Application for a Non-Material Amendment Following a Grant of Planning Permission

Land at Yiewsley Library and Former Yiewsley Pool,

76795/APP/2023/2503

Non-Material Amendment(s) Sought

North East (Elevation 08)
1 : 100

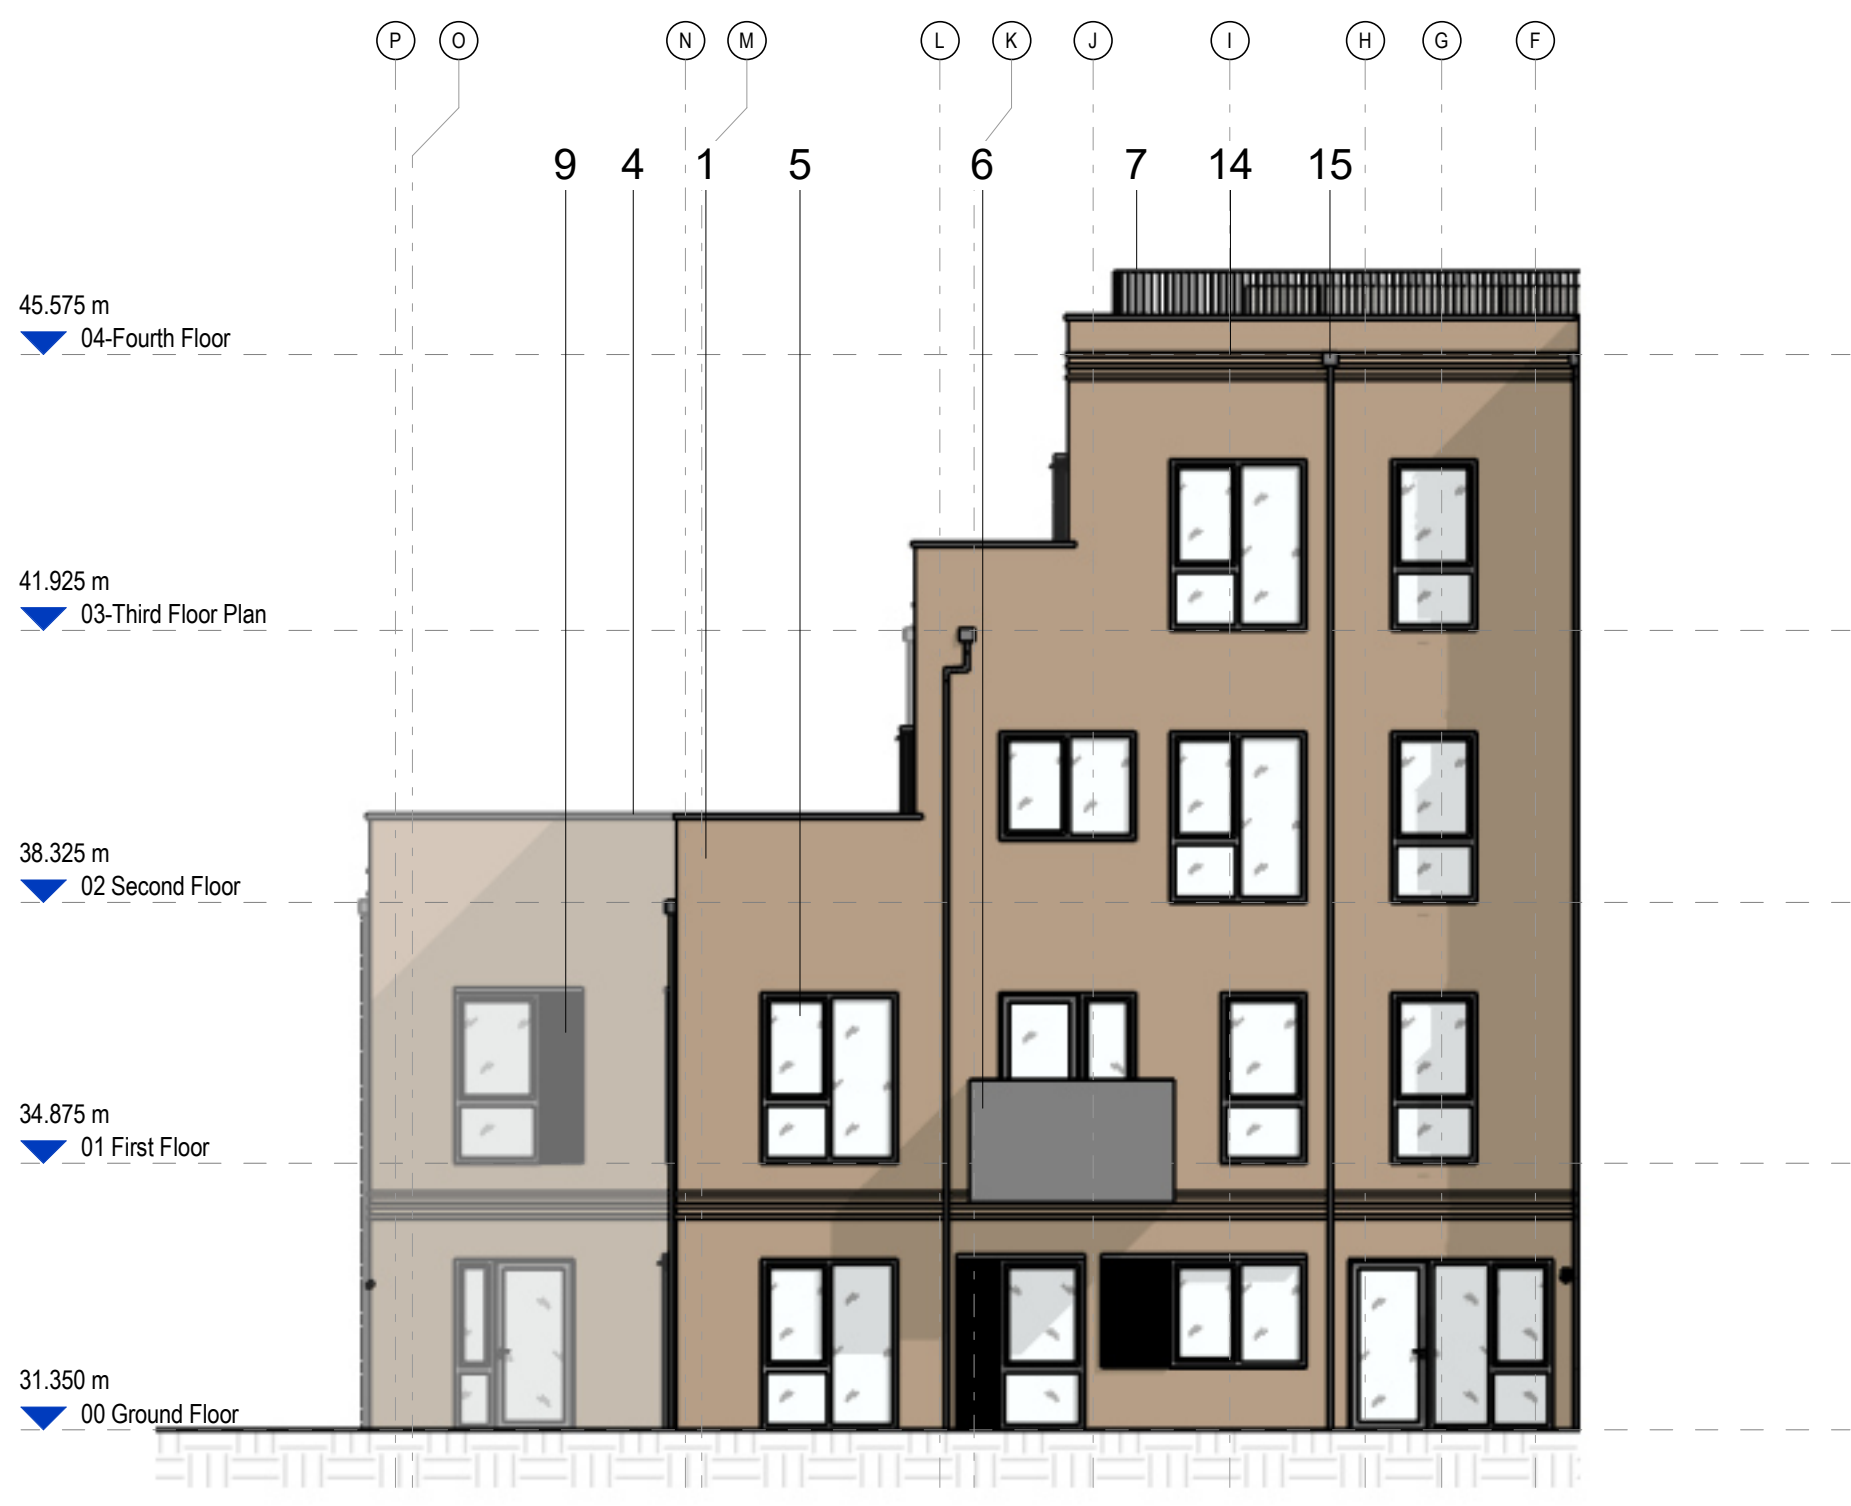
Louvers and shutter added to Rabbsfarm car park – The Shutter is a Secure by Design requirement and ventilation requirement for fire strategy.
